From: "Amelia Stroud" <Amelia.Stroud@arun.gov.uk>
To: "John Carver" [REDACTED]
Sent: 30 March 2011 14:44
Subject: Fernfield, Arundel Road

Title Proposed Tractor and Machinery store and workshop at Fernfield Arundel Road Norton Chichester West Sussex PO18 0JX		Client Mr and Mrs D Singleton Fernfield Arundel Road Norton Chichester West Sussex PO18 0JX
Scale 1:100	Date 02/11/10	Drawing No RA/10/1132rev A

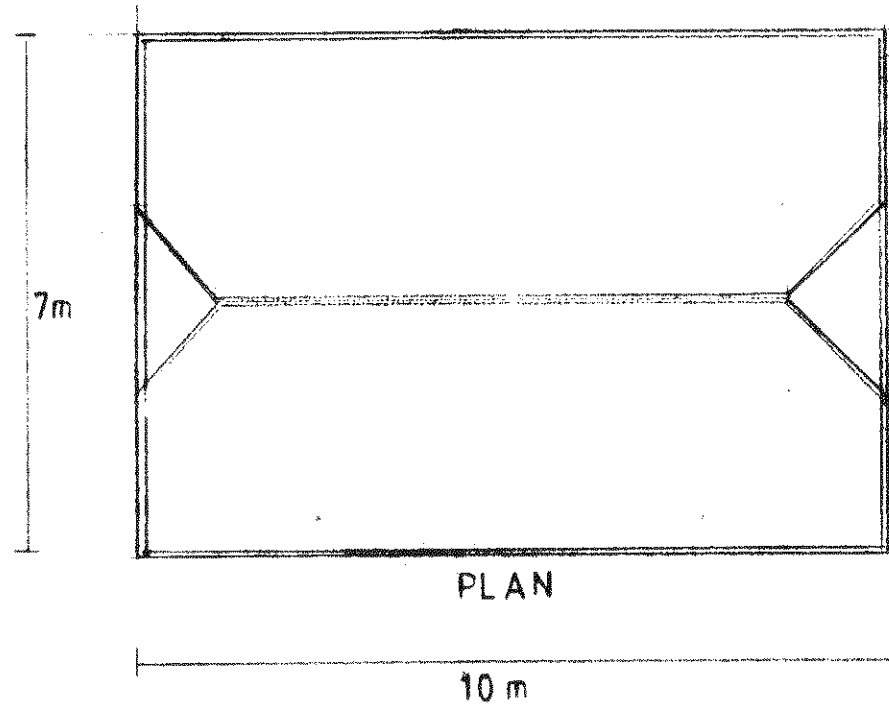
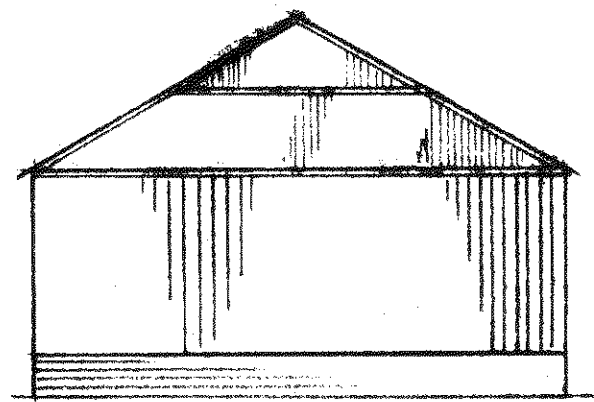
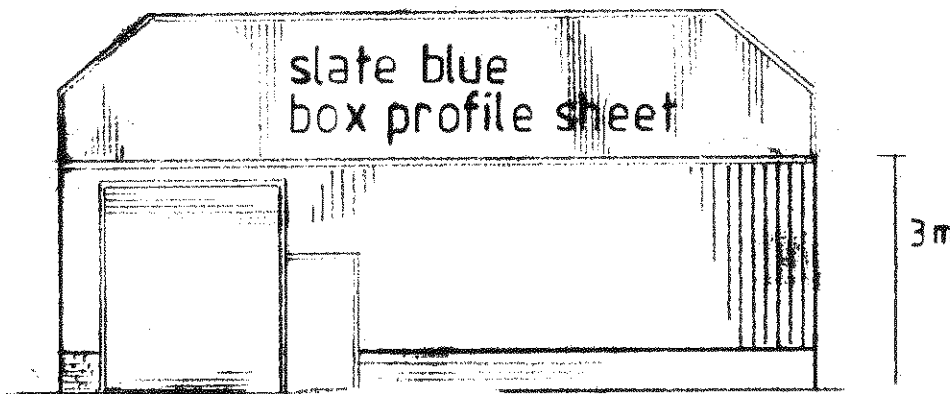
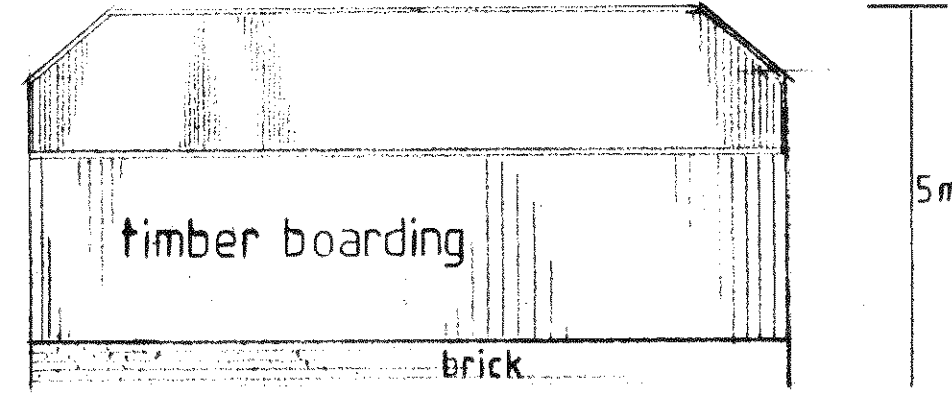
Thank you for the additional information regarding the above. I have discussed the situation with both my managers, and have shown them the information regarding the size of the equipment required for the grass cutting operation. Unfortunately, they are both still of the opinion that the maximum footprint of building that would be allowed would be a 7 x 10m barn, with a hipped roof reaching a maximum height of approximately 5m.

Thank you for you e-mail I have discussed the contents with my client who is a little disappointed. however he has instructed me to amend the original application in line with your proposal. I am going away for three days tomorrow night so will submit amended drawings etc on my return.
